From: Alasdair Harrison
Sent: 06 December 2011 12:51
To: 'Graeme Thorpe'; 'martin.nugent@lancashire.gov.uk'
Subject: FW: Applications

320110559P

Attachments: 05C revised site plan.pdf; passing bays.doc; 05E Revised passing bays.pdf

DWG -05E

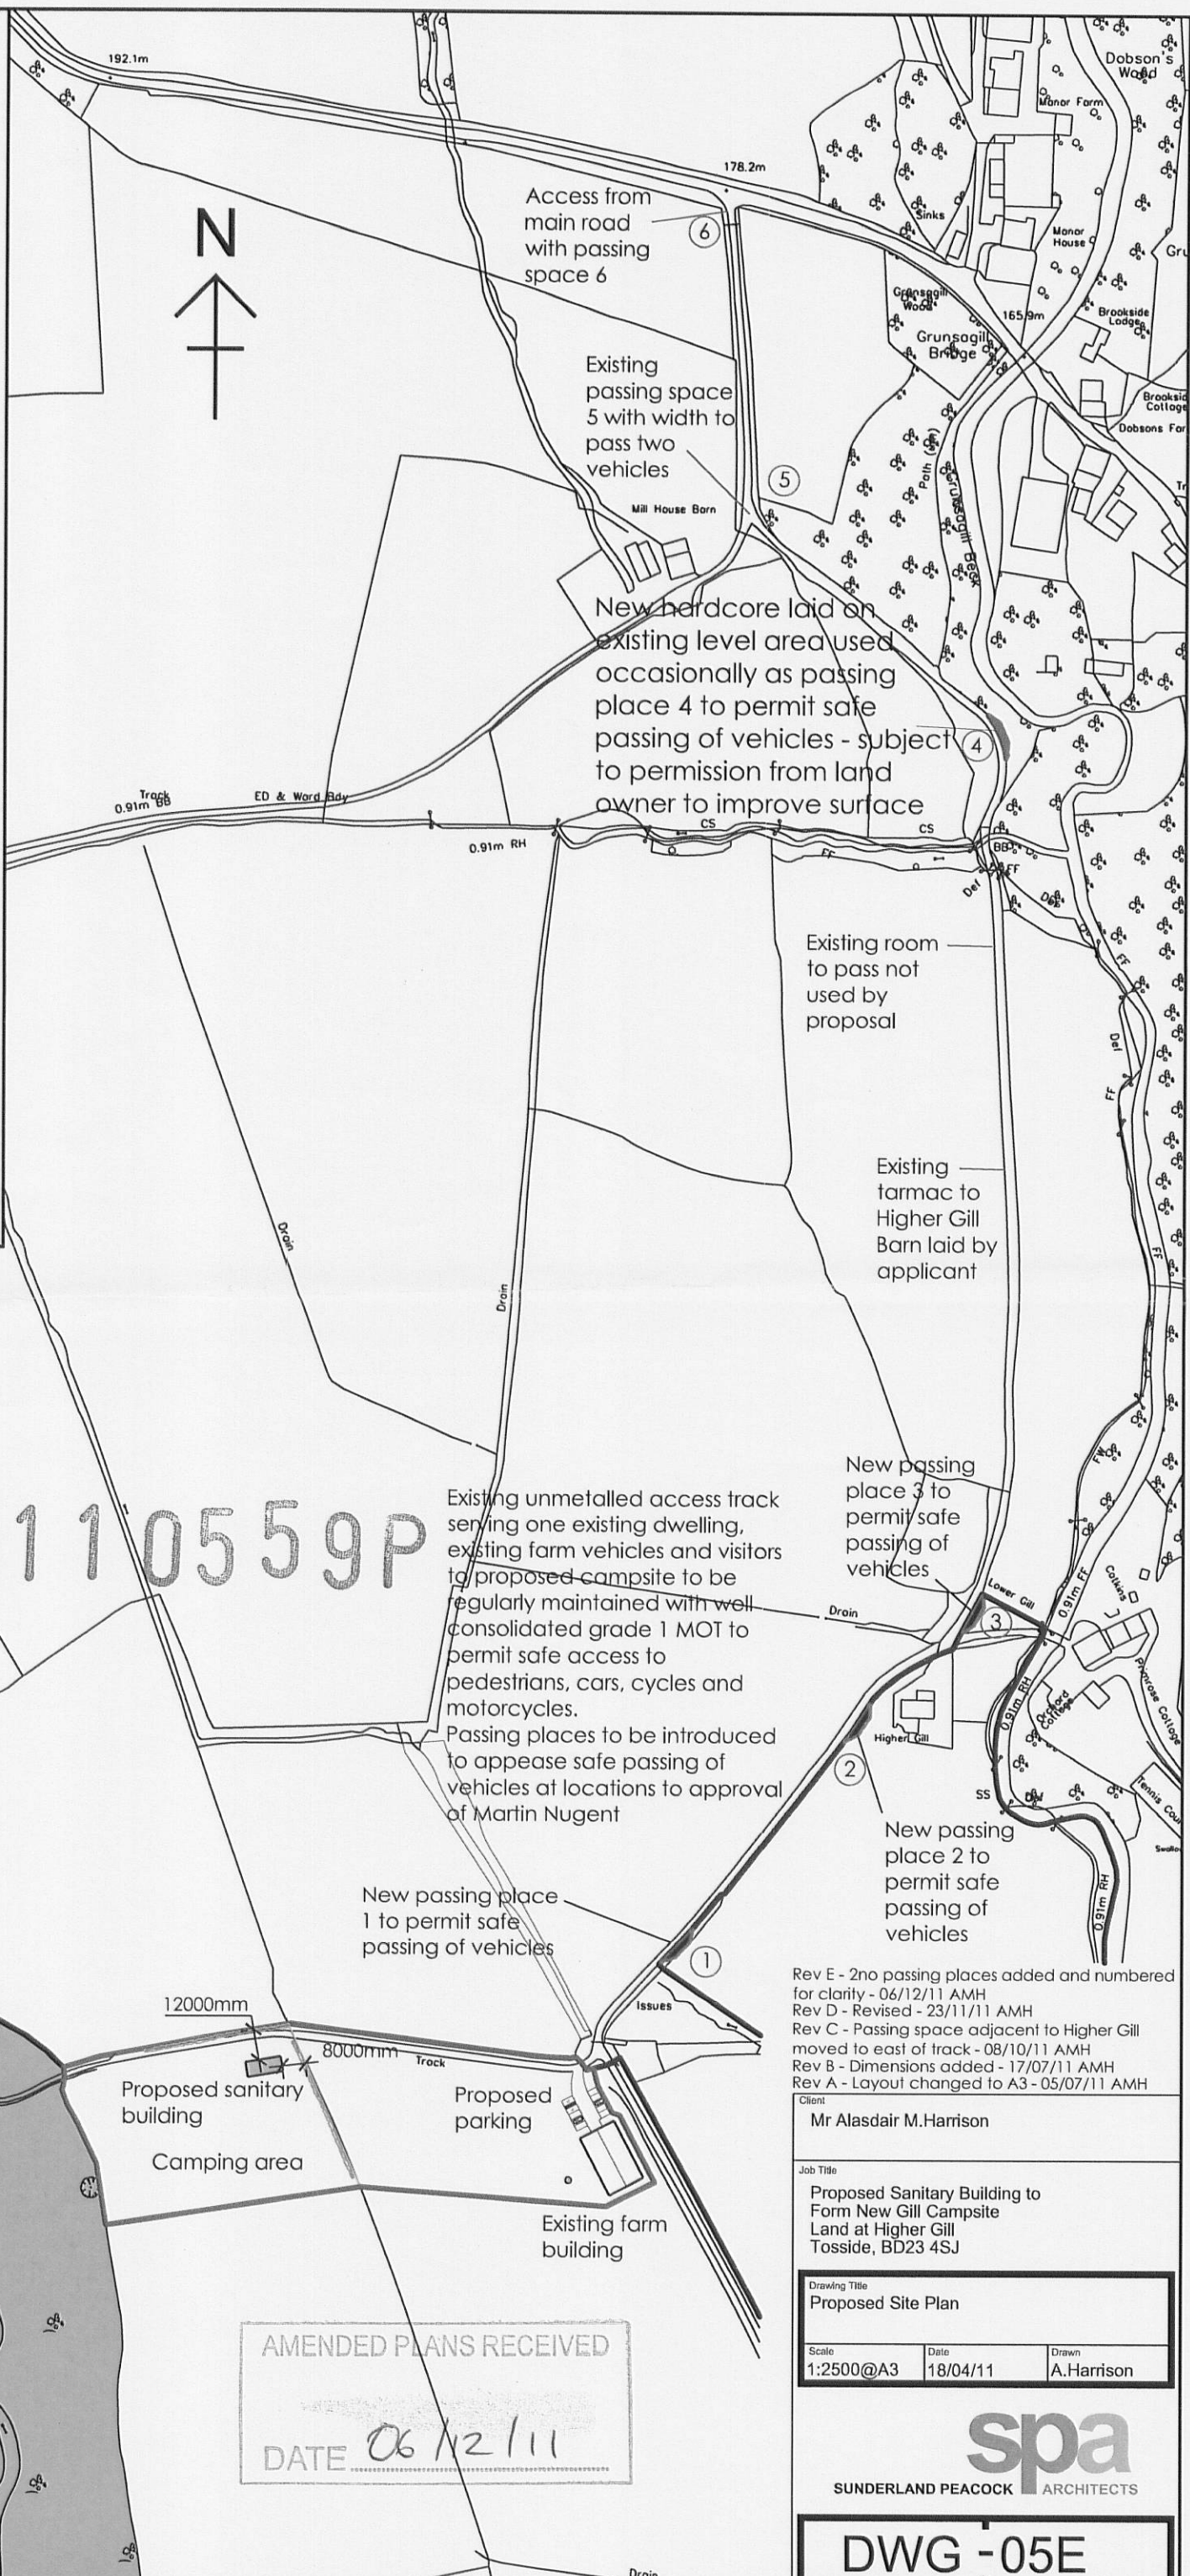
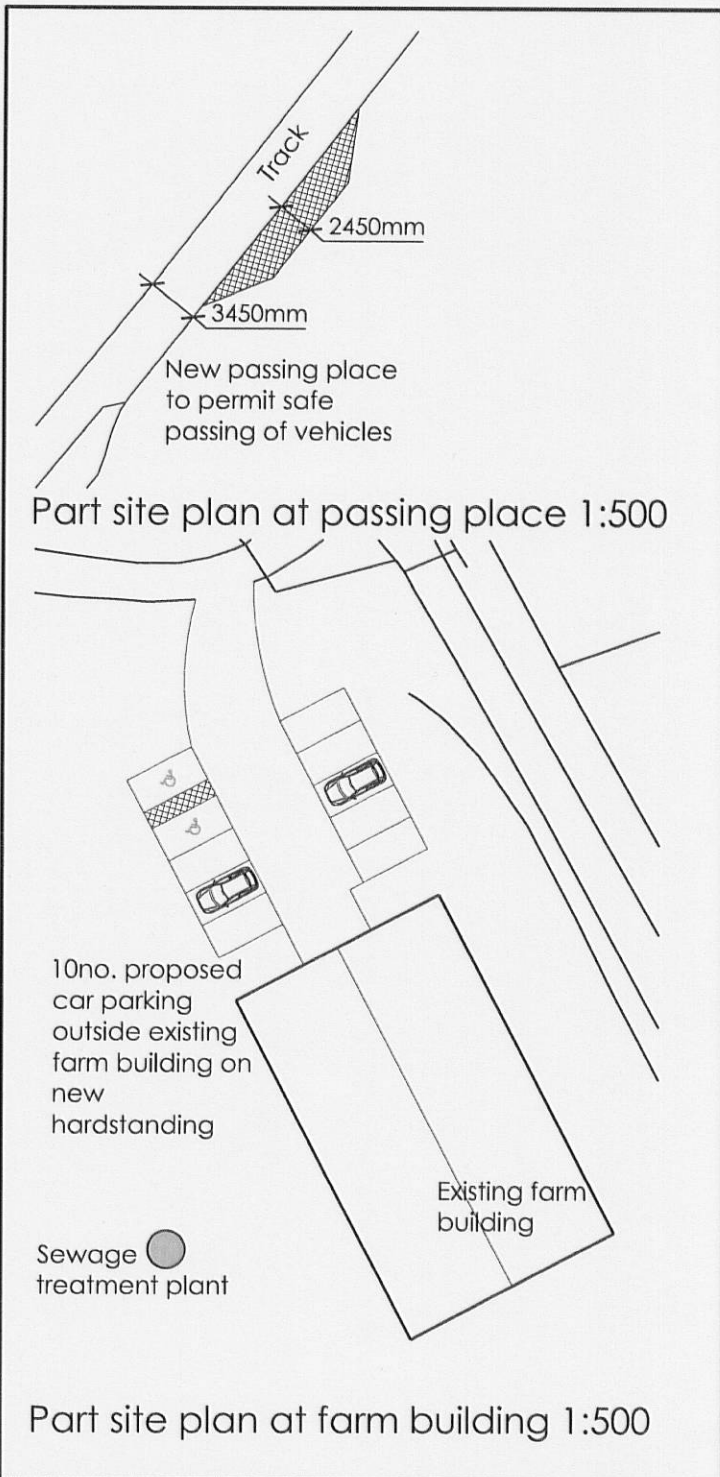
Further to my email and revision on 23.11.11 please see revision 05E attached and the below details of access to and from the proposal.

Passing bay 1 is positioned to the west of the track on our land.

Passing bay 2 is positioned to the west of the track just before Higher Gill Barn and the bend in the track on our land. There is a change in level at this point so has less ahead, a good place to form a passing bay.

Passing bay 3 is positioned to the west of the track just after Higher Gill Barn, after the bend on our land. The road is tarmac from this point. This is the bay that was previously on Stephen Downs land on revision 05B. I have moved it to the other side of the road on to our land in revision 05C yet Mr Downs seems to be insisting it is on his land in his correspondence with yourselves? I can request the deeds from our solicitor if required to prove this, it is the land we acquired with Higher Gills Barn over 15 years ago. There is a semi established space on his land to the east but I have no problem in forming one on our side to the west.

From here the track is straight until the cattle grid. There is the existing grassed passing bay which is on Mr Downs land and used to drive into the field to park / access the land. I will ignore it for the purposes of his application and no longer propose to lay clean hardcore on it.

Passing bay 4 is positioned to the west of the track just after the cattle grid. This cattle grid is the boundary between Stephen Downs land and Andrew Harpers land. Bay 4 is the existing space on Andrew Harpers land. It is just before the steep section of the track and is used to wait in if somebody is coming down the hill. I propose to maintain it at my expense with clean hardcore. Andrew Harper has not objected to the application.

Passing bay 5 is at the top of the steep section of the tarmac track and is wide enough here to pass two cars, with visibility to the previous bay and where the main road junction is.

Passing bay 6 is the end of the track / junction with the main road and has sufficient space to pass several large vehicles easily clear of the main road. It is wider than the main road.

This arrangement of six passing spaces is entirely independent of Mr Downs land and I feel forms sufficient passing alternatives to ease traffic. This arrangement is certainly better equipped with passing bays than many of the surrounding main roads. The longest section of track without a surfaced designated 2450mm wide passing bay is 315m, between bay 3 and 4 and is a straight section of road.
